**Written Representations**

from  
**Norfolk Wildlife Trust**

**In the matter of:  
The Drovers Solar Farm**

**Planning Inspectorate Ref: EN0110013  
Norfolk Wildlife Trust Registration Identification ref: [REDACTED]**

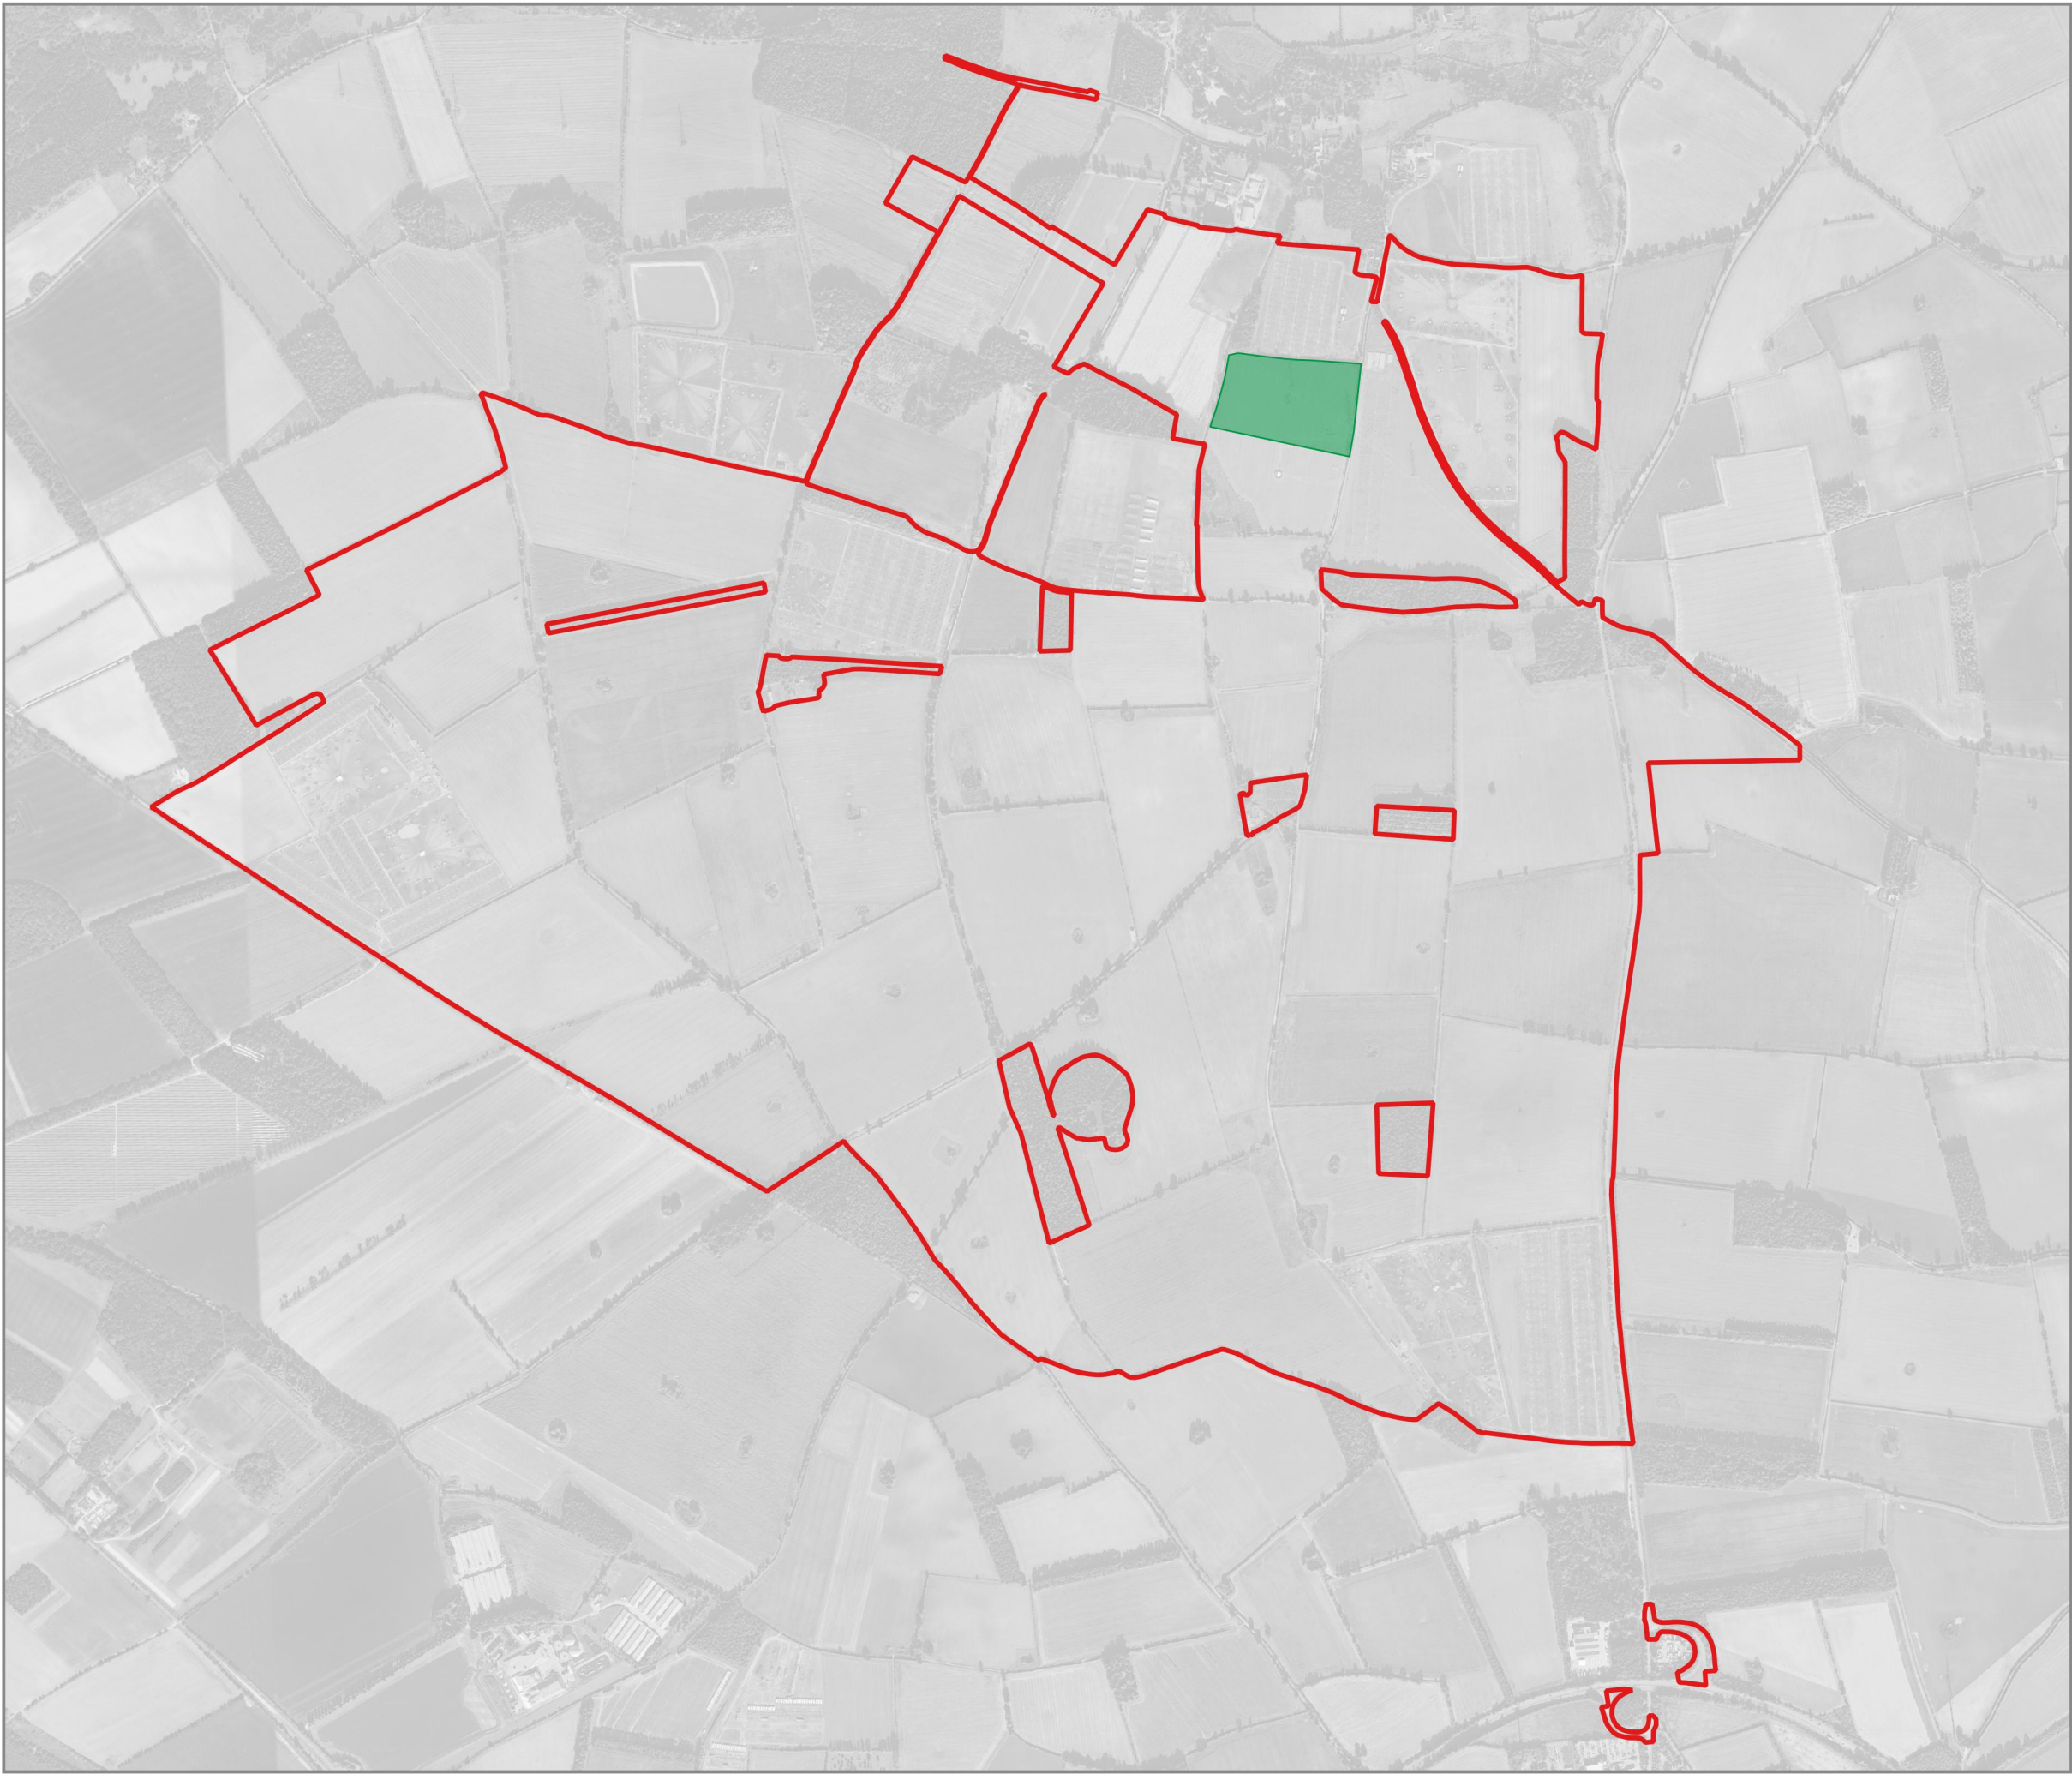
17. We note that new pylons will be installed and that this pylon route will run straight through the new area proposed for skylark and curlew mitigation. Installing pylons in an area proposed for curlew mitigation could significantly undermine the success of the area by causing issues of collision for adult

birds and by providing perches for predators. Guidance is that new infrastructure such as pylons should not be placed in sensitive areas.
